Recommendation Report for Planning Permission for Works or Extension to a Dwelling

REF NO: WA/92/18/HH

LOCATION: Lillypad
Yapton Lane
Walberton
BN18 0AR

PROPOSAL: Demolish existing conservatory, erection of single storey rear extension with balcony over and 2 No. new rooflights on south elevation.

AJ SALTER & SON
Architectural Technicians
and Surveyors
50 WINDSOR ROAD, WORTHING,
WEST SUSSEX, BN11 2LY
Tel/Fax: (01903 209496)
E-mail: ajsalterandson@hotmail.com

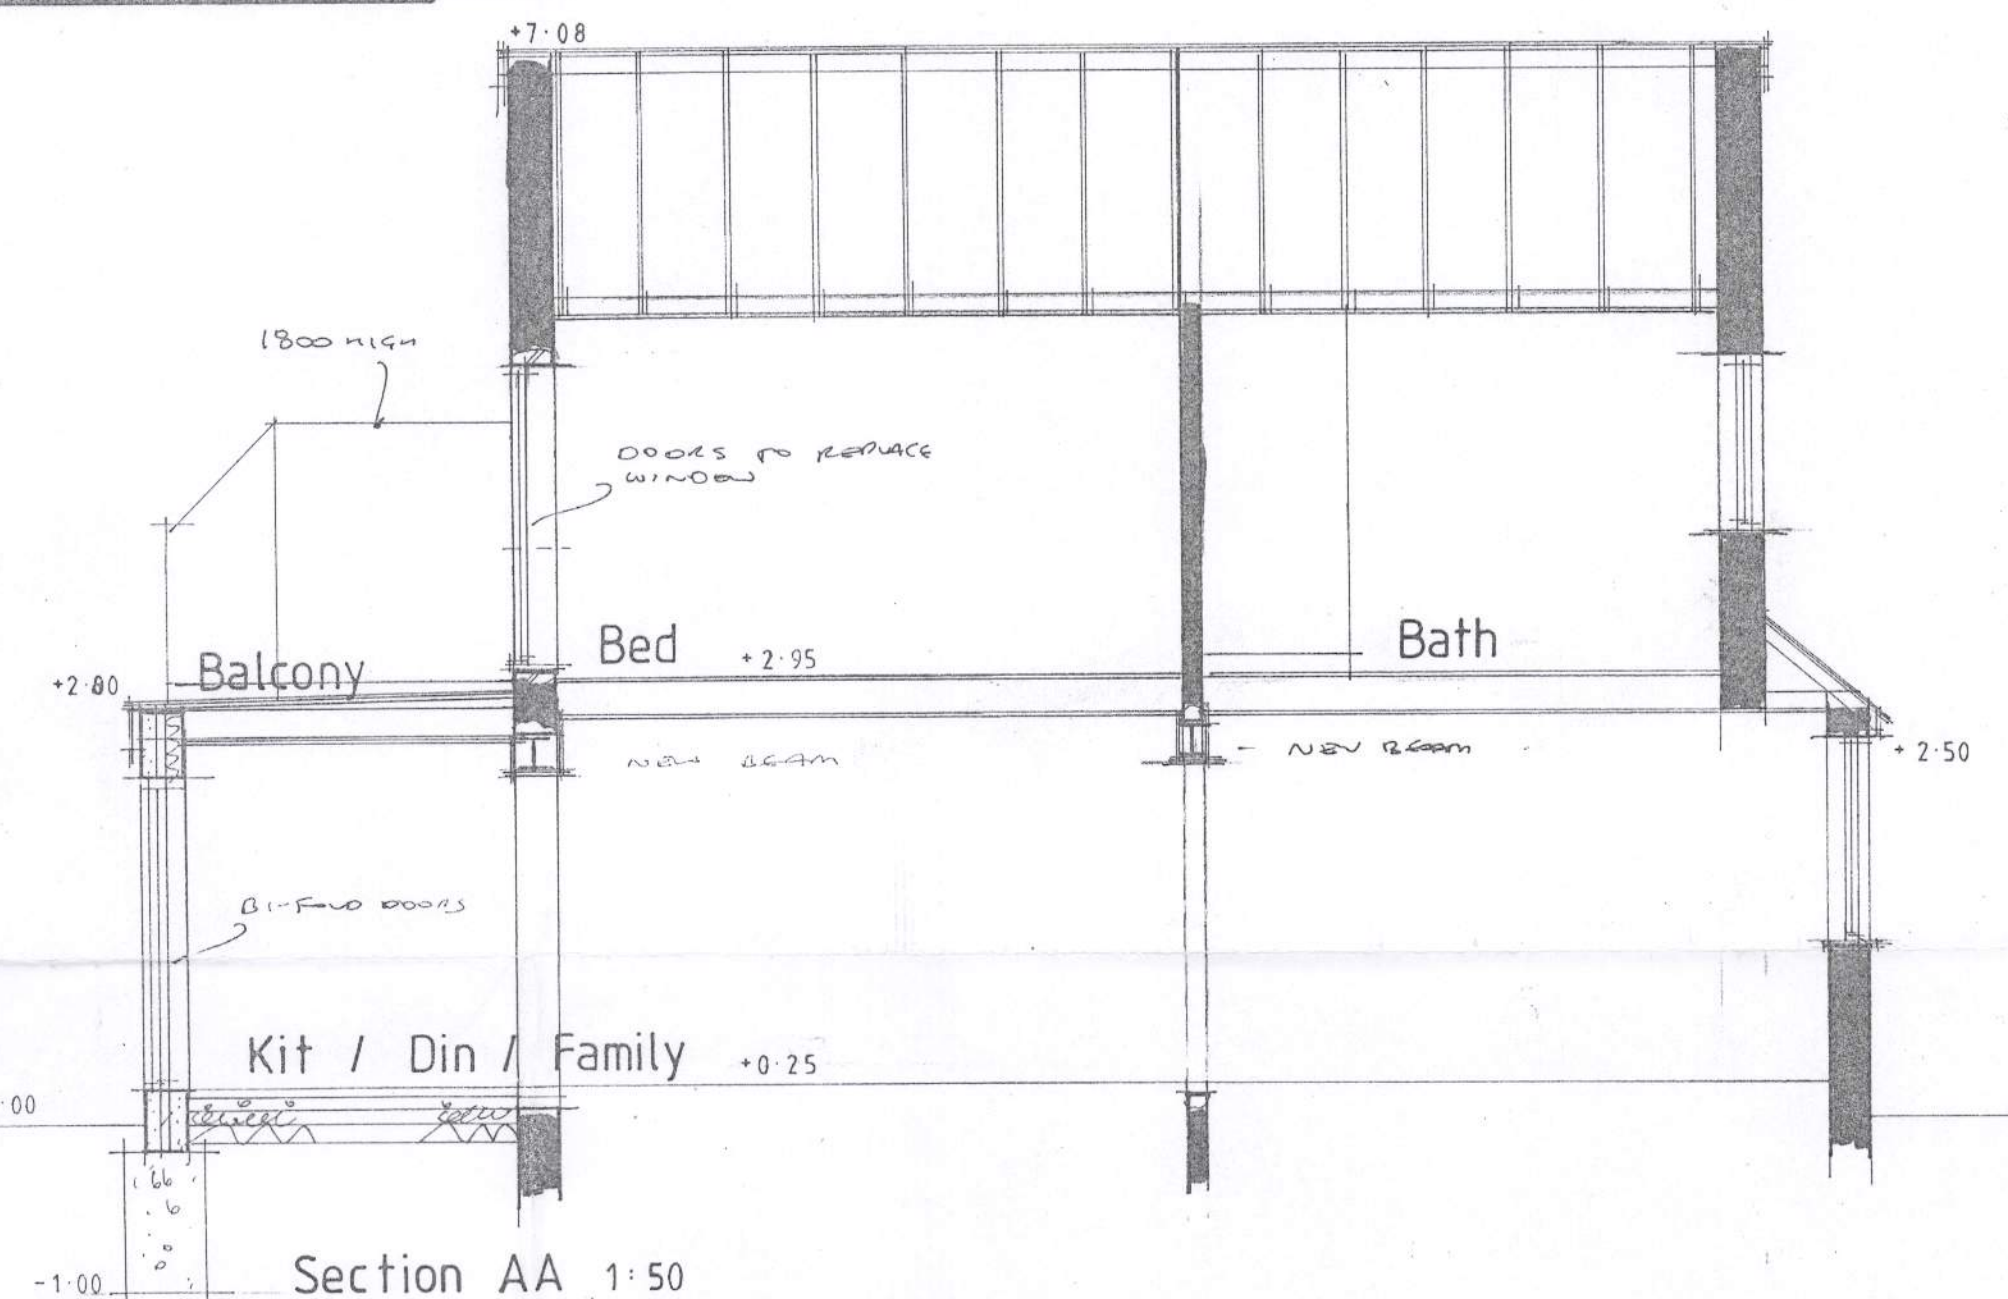
The balcony addition would create a raised platform, enclosed along its north and southern elevations by a 1.8m high obscure glazed screen. By virtue of the current outlook from upper floor windows, the precedence set by the balcony serving the rear of Stafford Cottage to the North. On balance a raised platform with obscured glazing is considered acceptable and would not be significantly detrimental to the impact on the neighbouring residential amenities of adjacent occupiers. The balcony is therefore permitted subject to condition for the retention of obscure glazing to the balcony.

- 4 The obscure screening shown on the submitted plans shall be installed prior to the first use of the balcony and be retained thereafter in perpetuity.
